Our reference: ECM: 9685600
Contact: Gavin Cherry
Telephone: (02) 4732 8125

18 August 2021

Response to Submissions for St Marys Resource Recovery Facility (Borg) SSD-10474

STORMWATER DRAINAGE STRATEGY

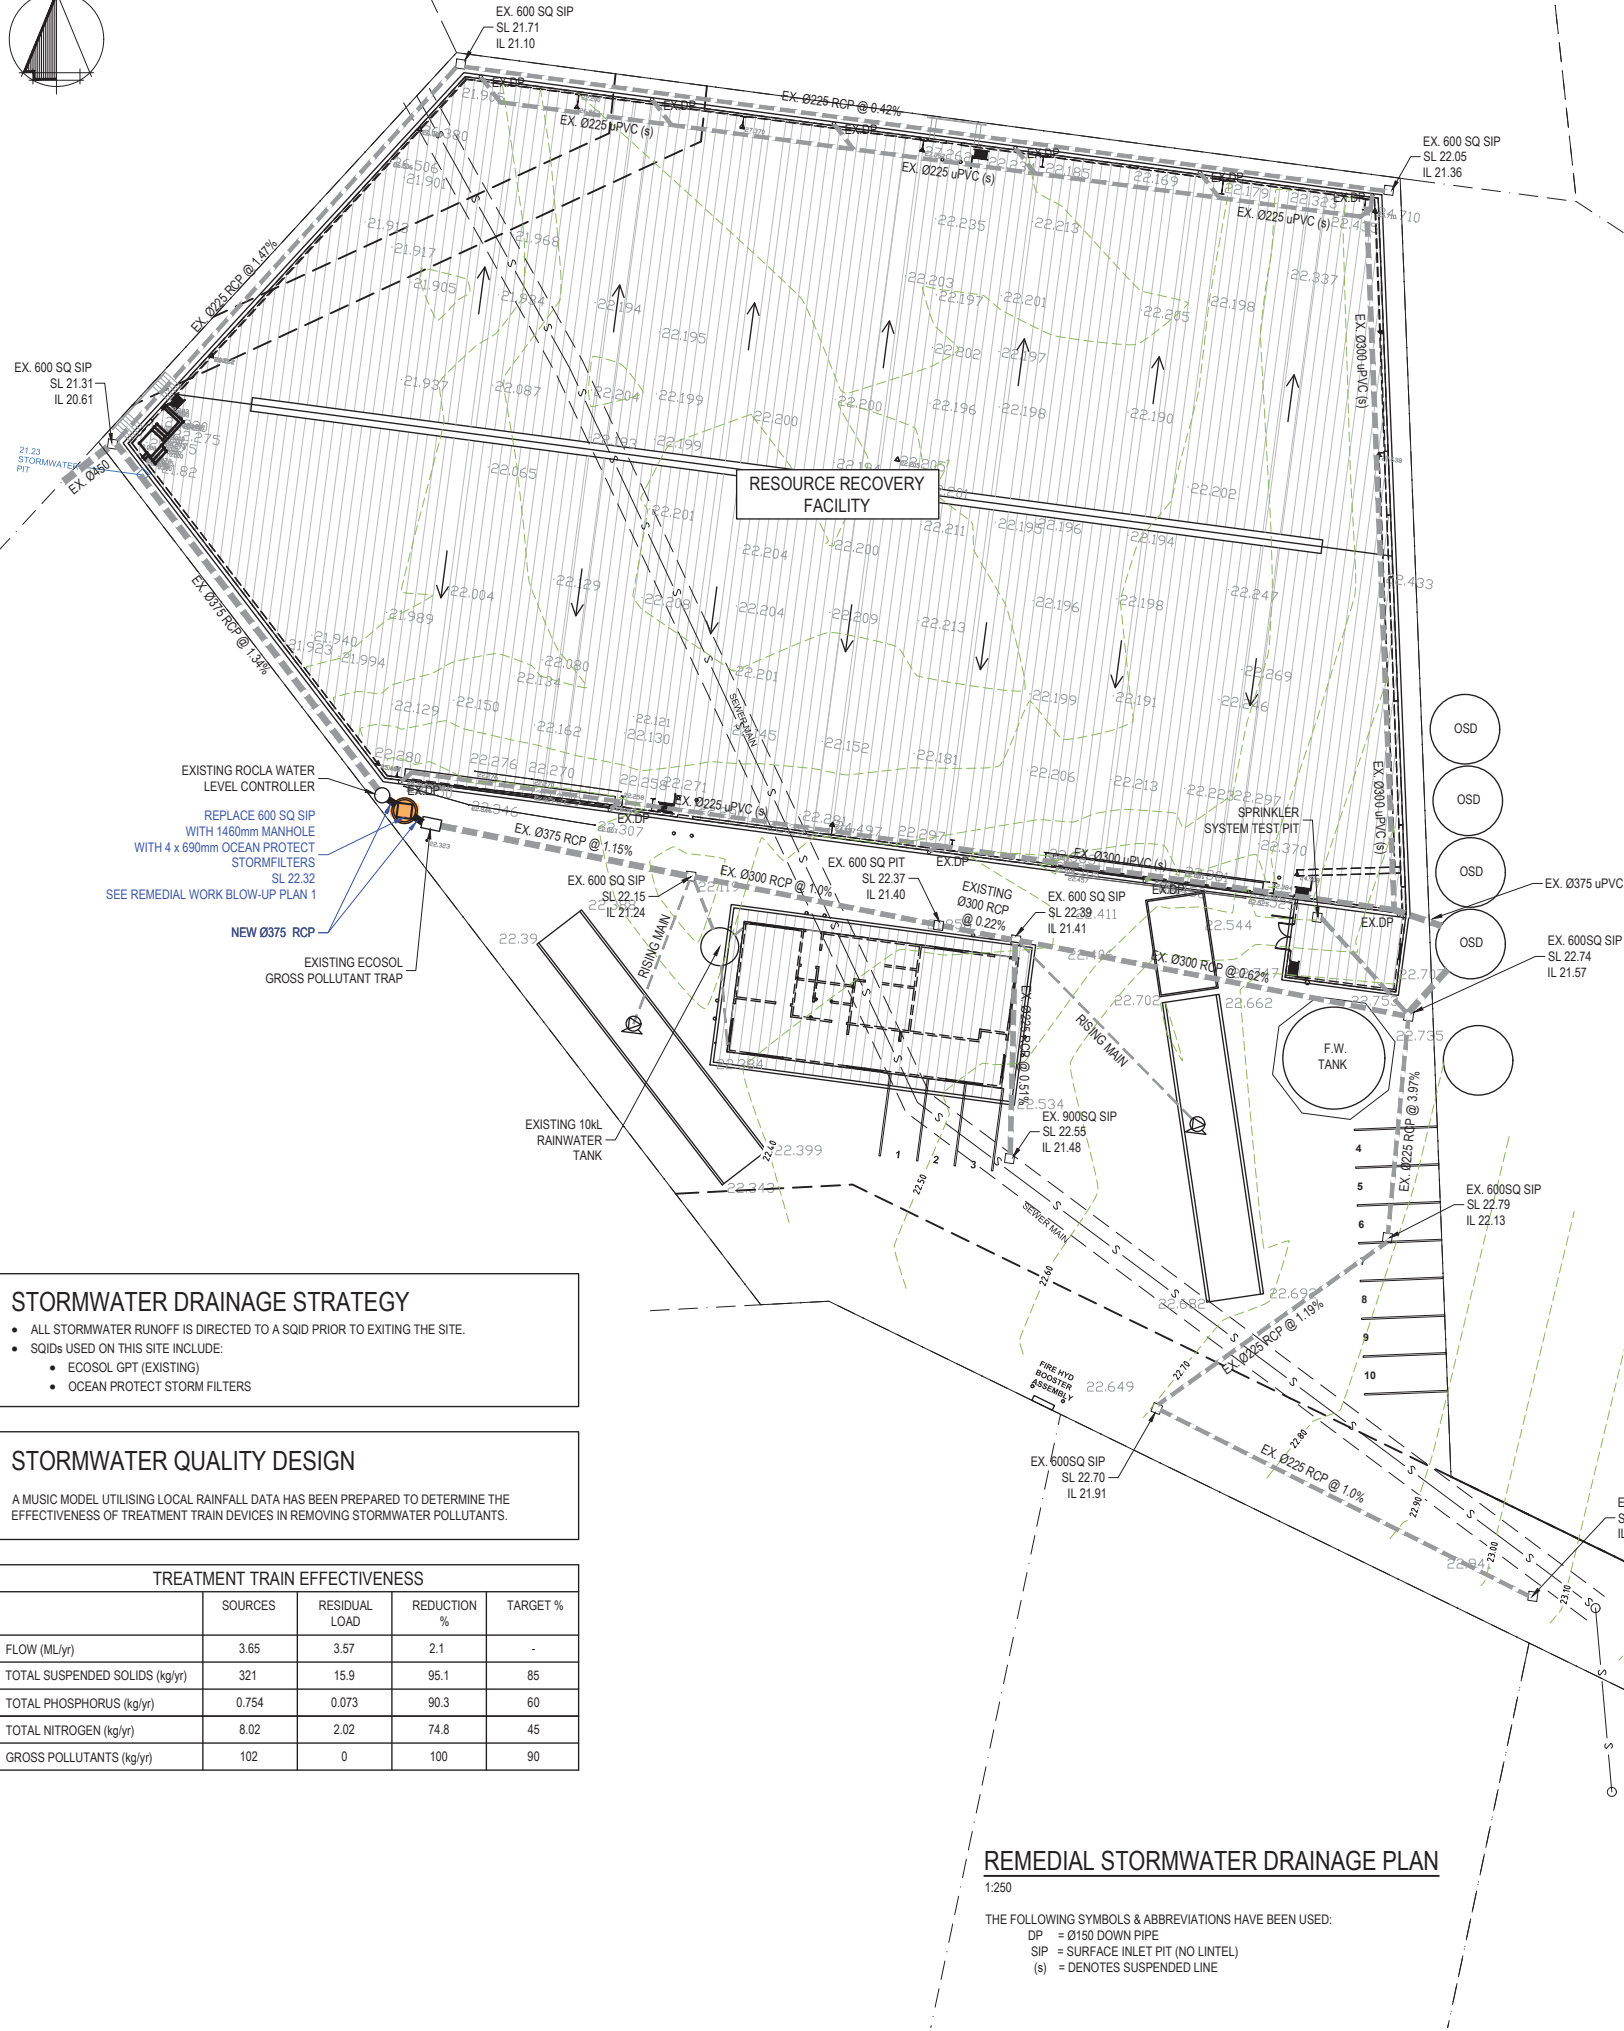
It is noted that the updated Stormwater Management Report by Eclipse Consulting Engineers, reference 10113-002-smp, Issue 3, dated 13 May 2021 contained an earlier version of stormwater plans by MPG, reference 2016-0217, issue C, dated 26.20.2016. The previous version of the Stormwater Management Report by Eclipse Consulting Engineers, reference 10113-002-smp, issue 2, dated 21 February 2021 contained more recent stormwater plans by Eclipse Consulting Engineers, reference 10113, issue A, dated 23.02.2021. The more recent stormwater plans propose an additional 'Stormfilter' stormwater treatment device.

It is requested that the more recent stormwater plans by Eclipse Consulting Engineers, reference 10113, issue A, dated 23.02.2021 be relied upon for the purpose of determining the development application.

As the OSD system relies upon an above ground tank system that is located on the adjoining property to the east, it is also considered necessary that condition B52 of SSD-8200 be imposed within the determination on this matter, which requires either both lots to be consolidated or provision of a drainage easement be created.
